**El Paso County Planning and
Community Development
Department**

Administrative Relief Application Packet

ADMINISTRATIVE RELIEF CHECKLIST

A1.3 PLOT PLAN

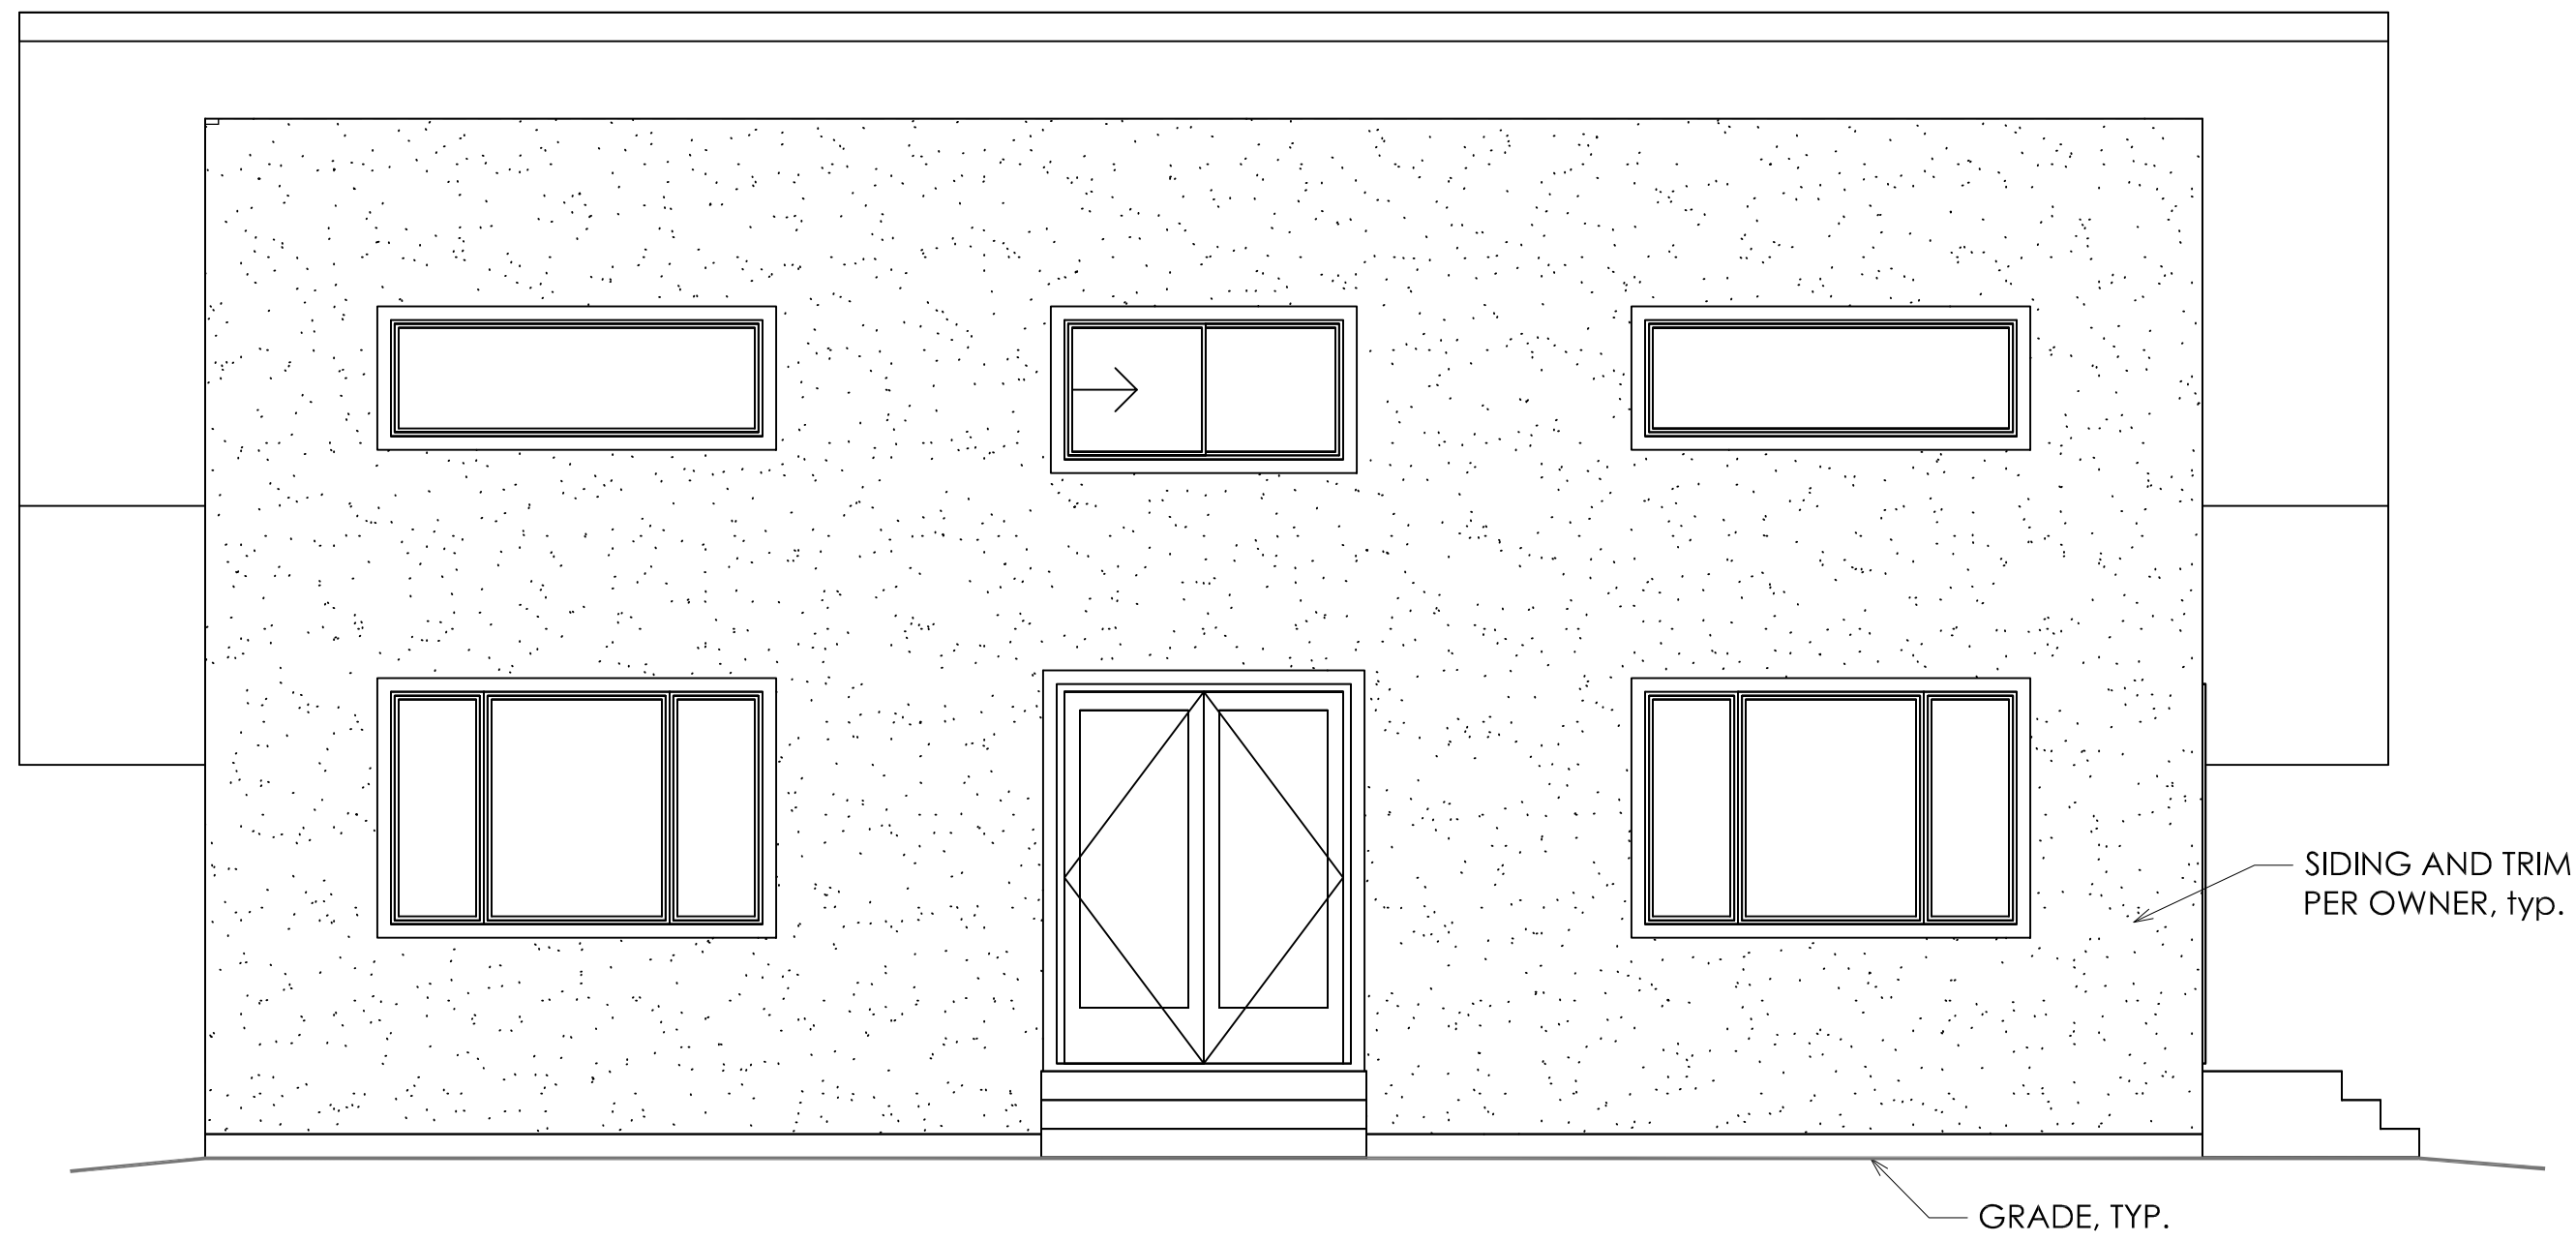
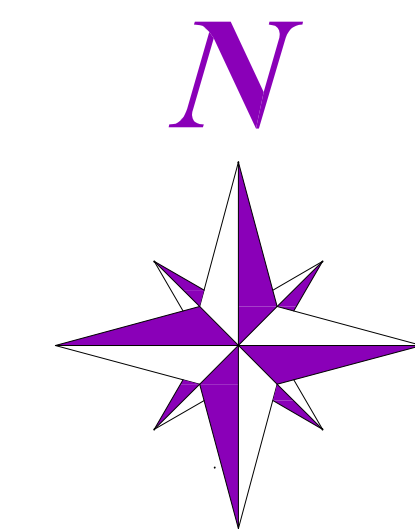
See note on Site Plan regarding size of future ALQ. Add a statement in here that you are also seeking relief for the size of the proposed future ALQ for up to 1800 sq ft.
